ADDENDUM

Project: Science Building Research Wing Expansion

Addendum: No. 4

Date: May 12, 2004

**A2.1**

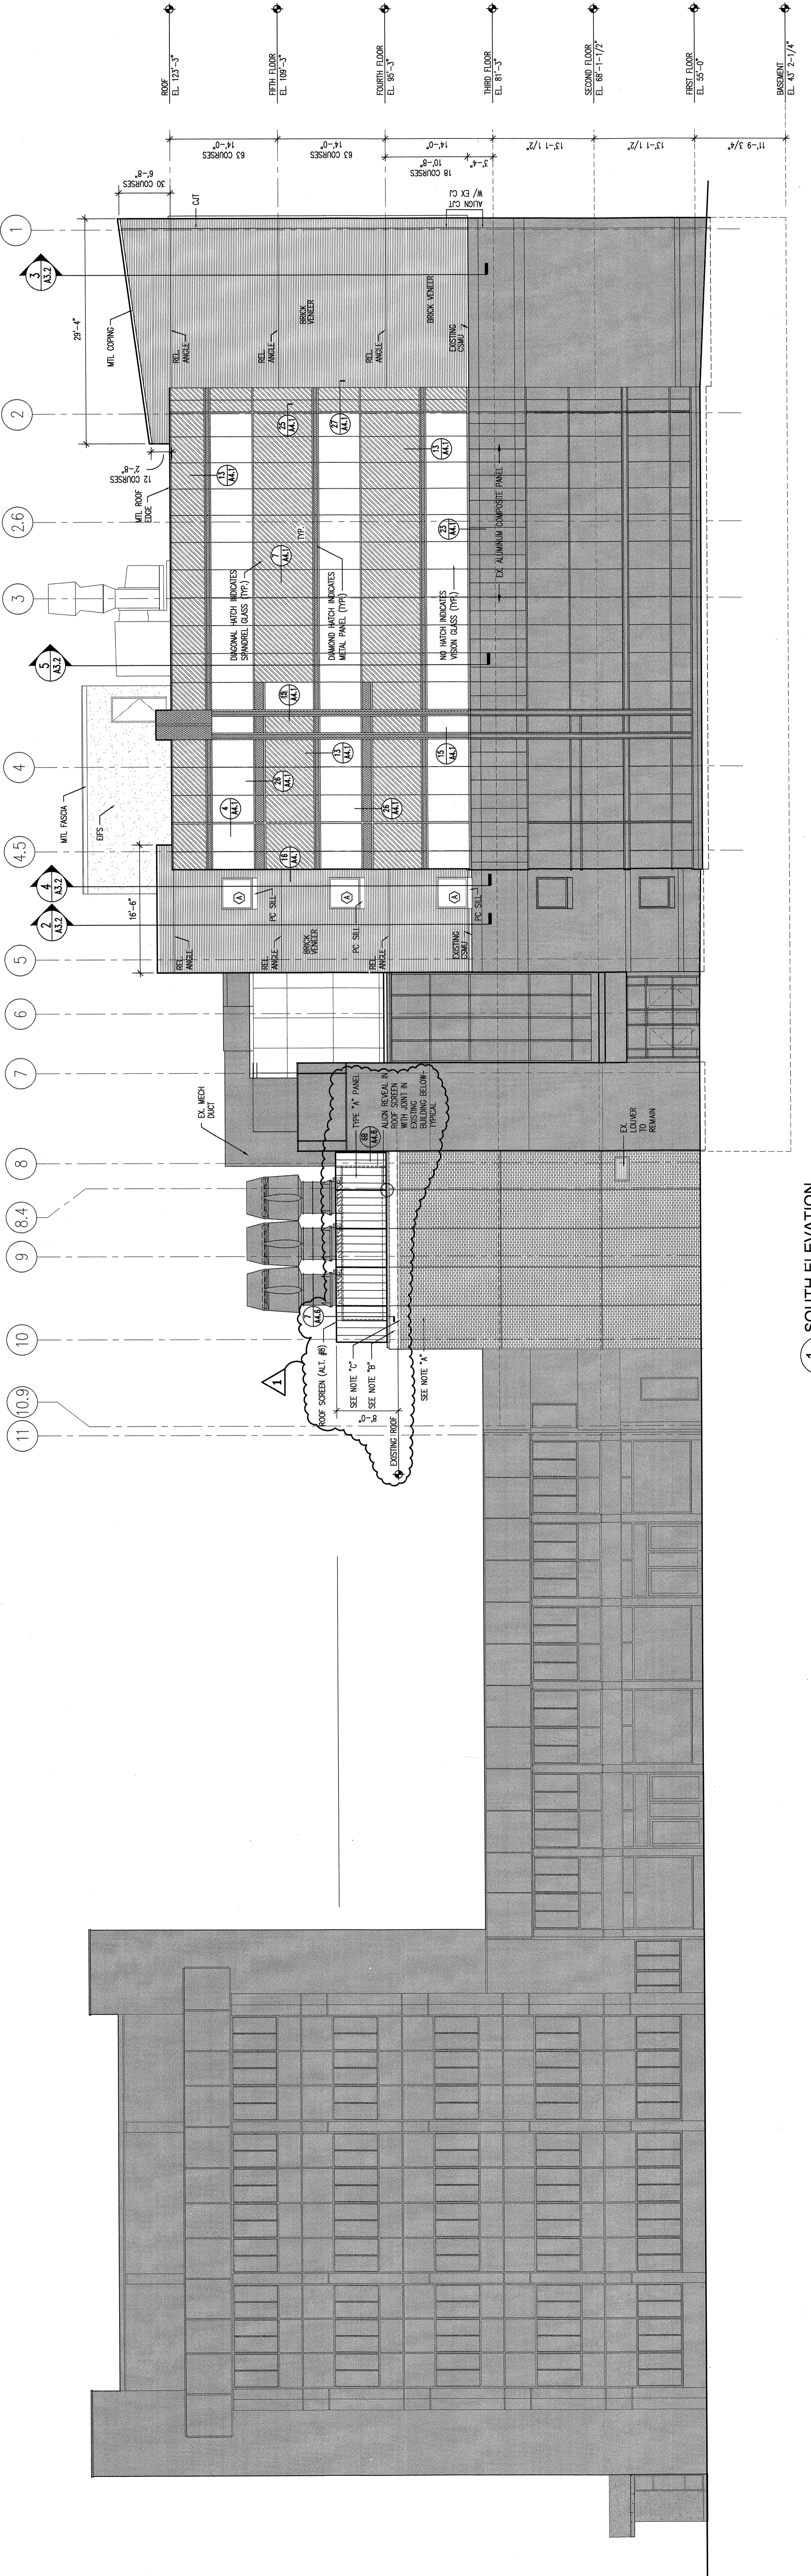
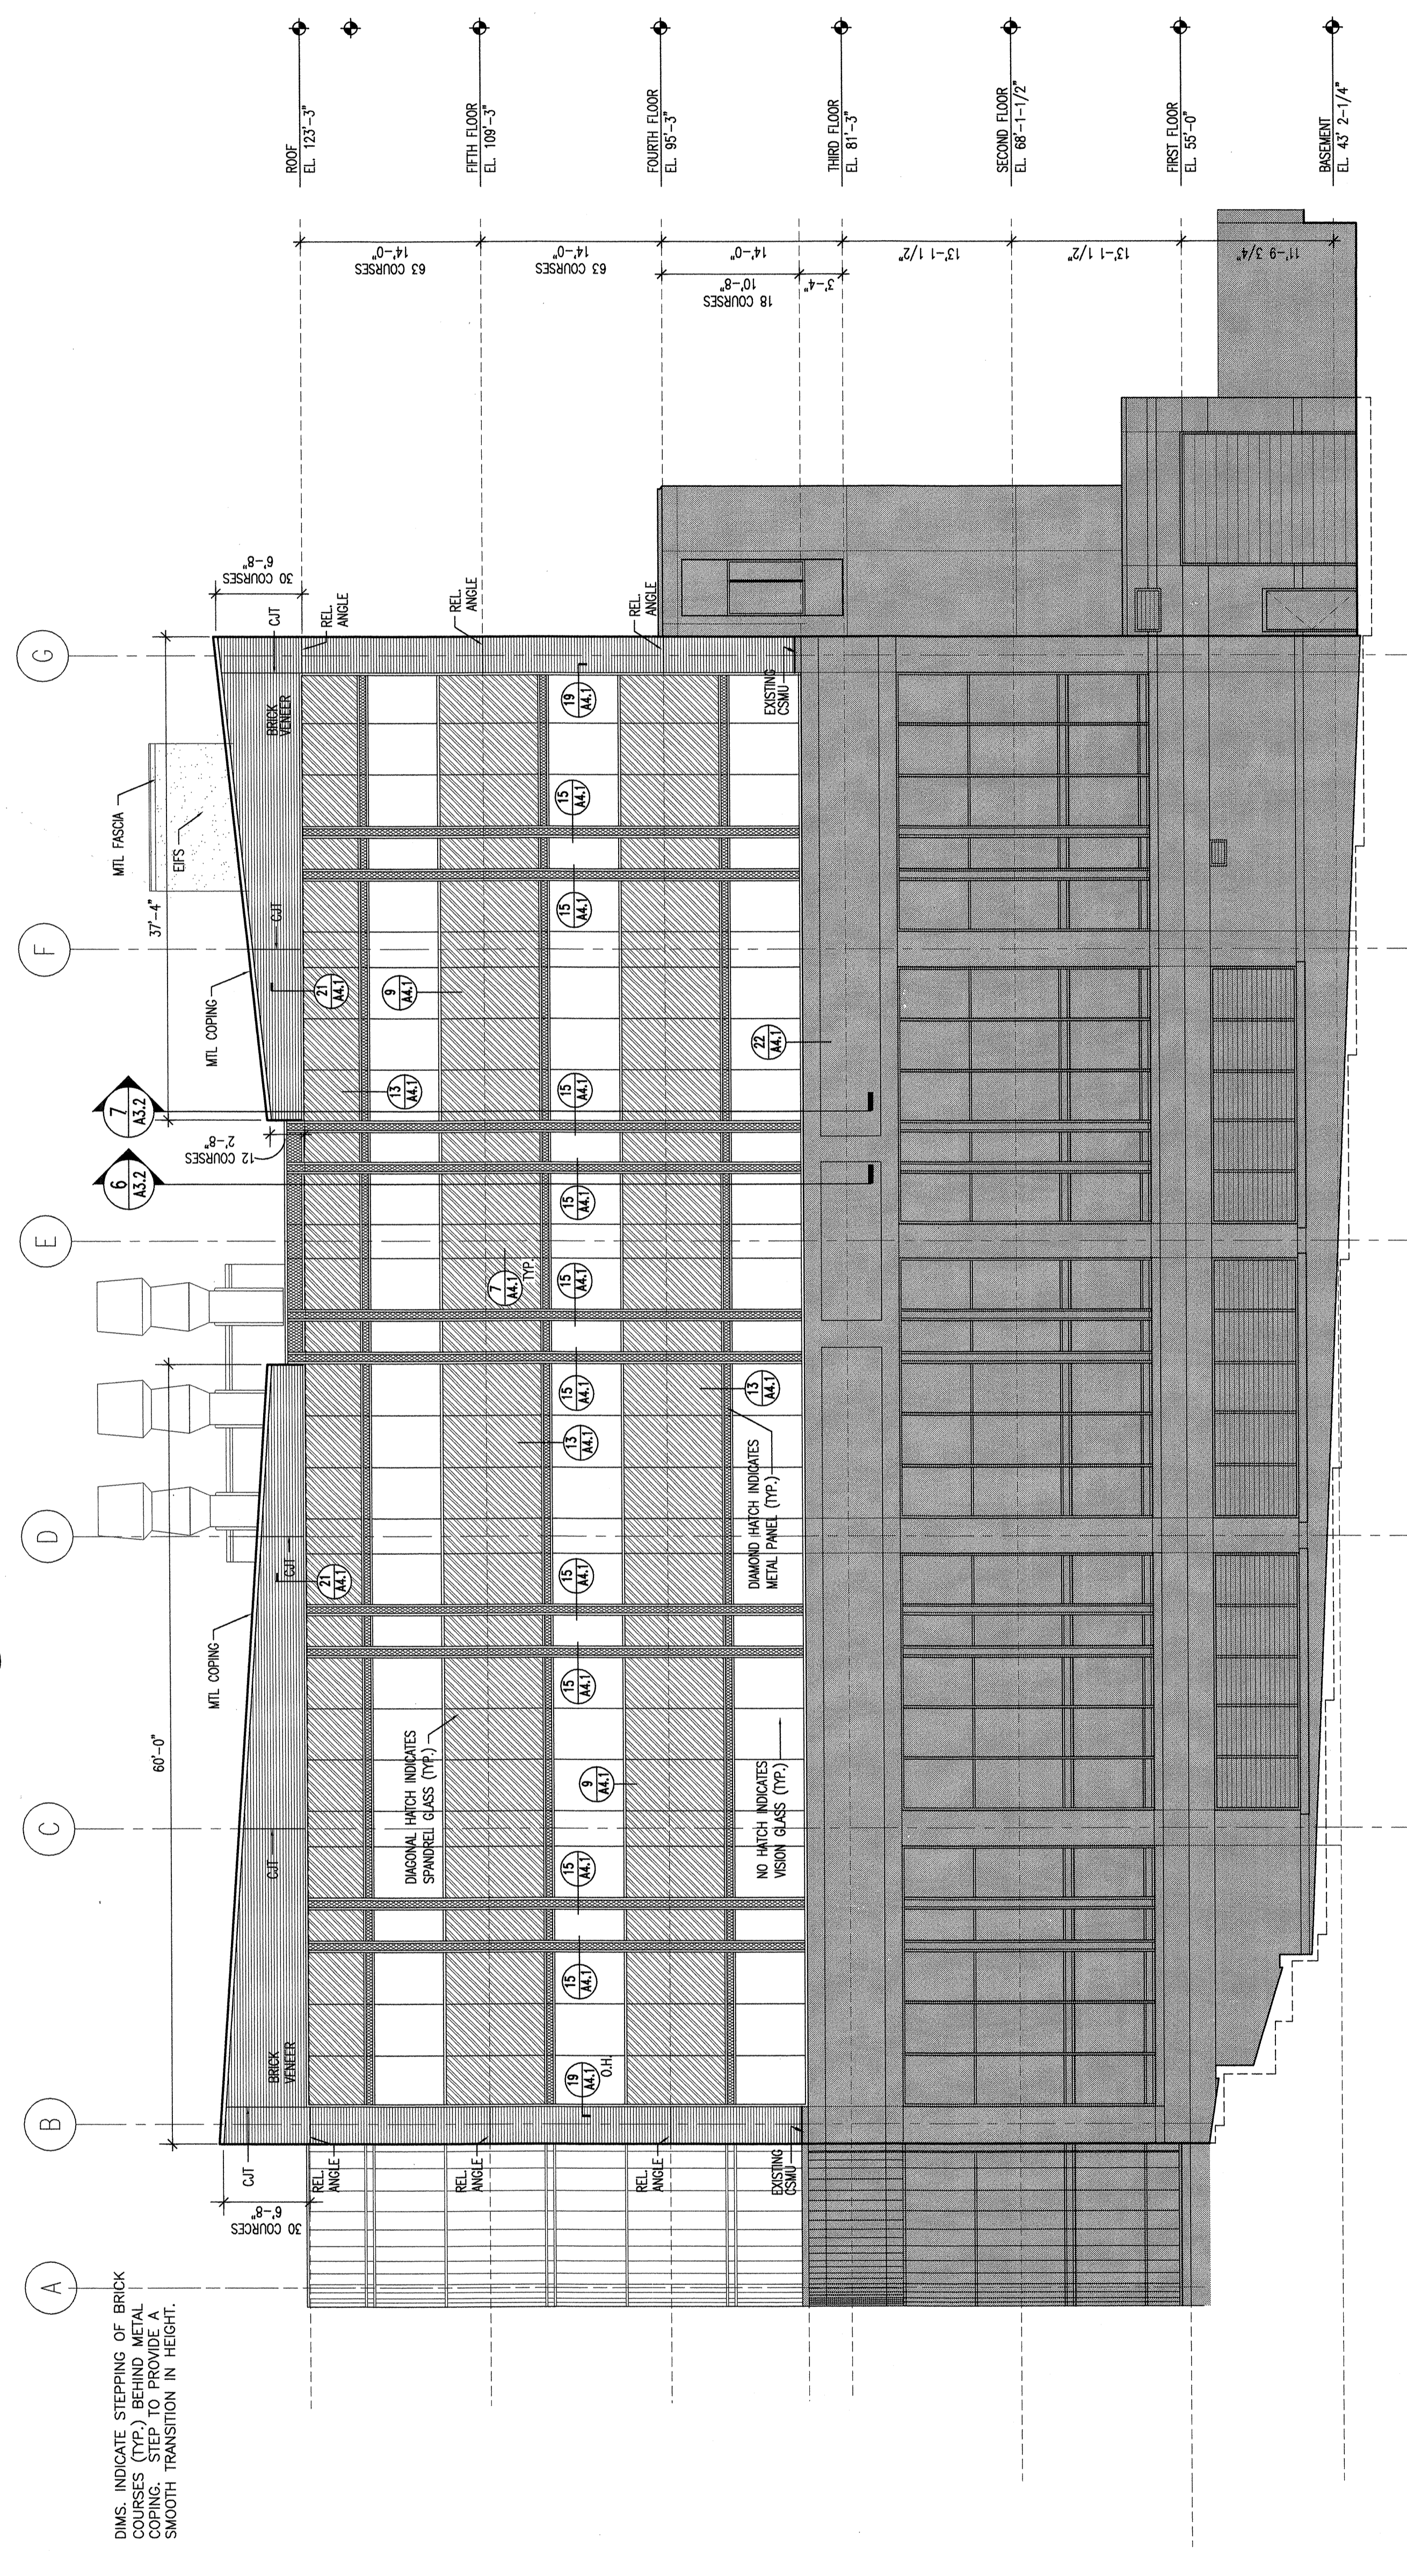
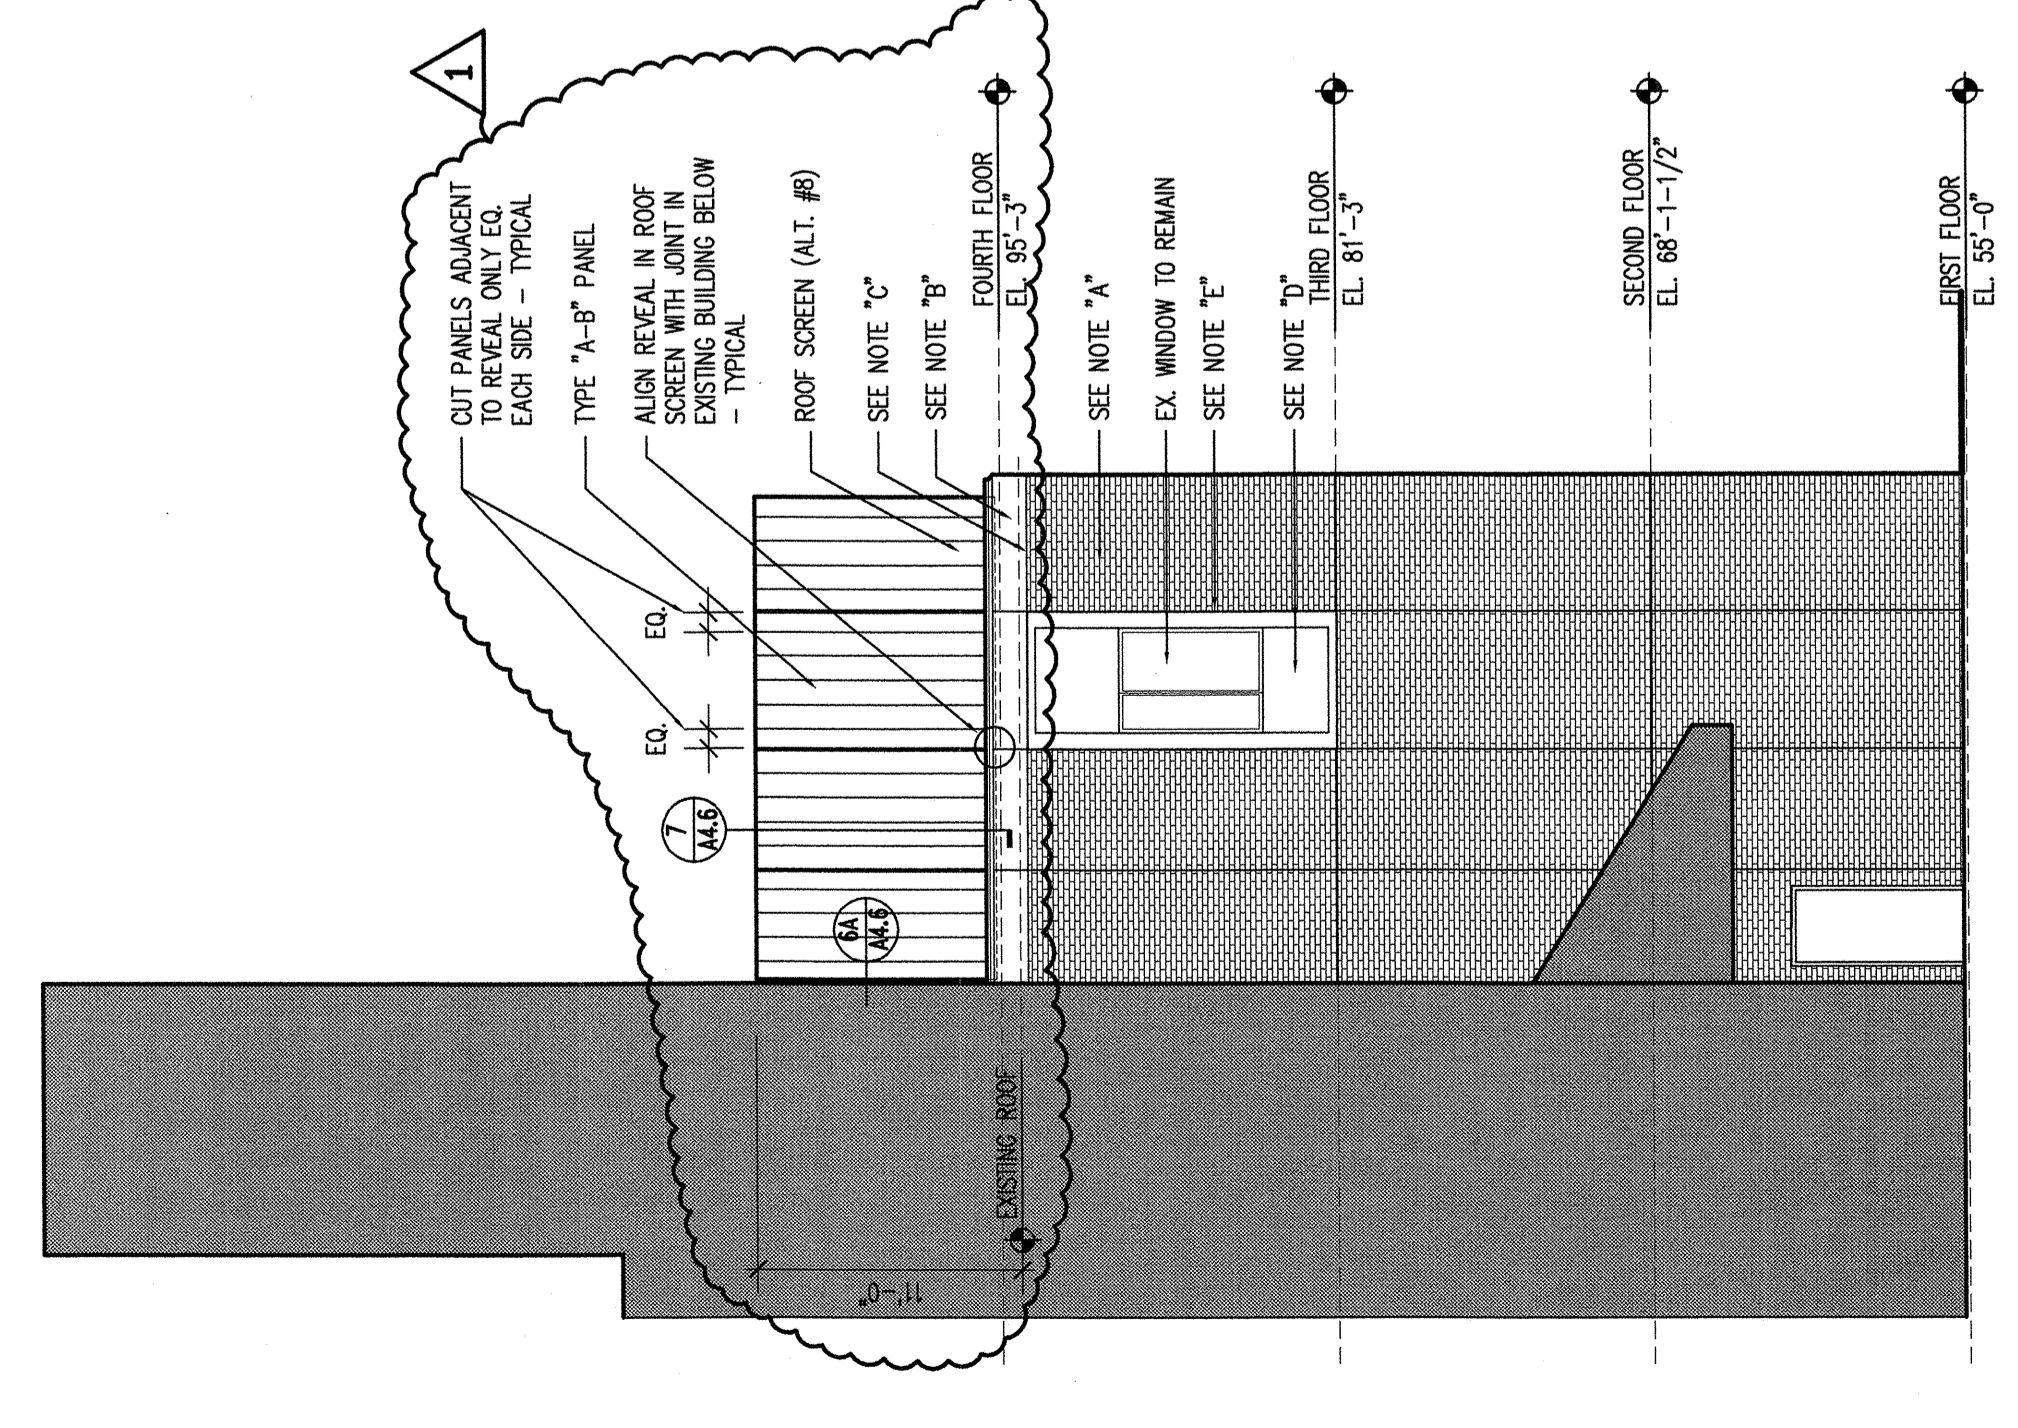
1. 1.02 A: Add subparagraph 3, as follows:
 3. Cutting, patching and flashing around vertical supports for rooftop acoustical screens.
2. 1.02 B: After the word "Exhaust," insert "and Alternate No. 8, "Rooftop Acoustical Screens." After "01230" insert "(as amended)."

| 2. | A 2.1 | Exterior Elevations | Revision 1 | May 12, 2004 |
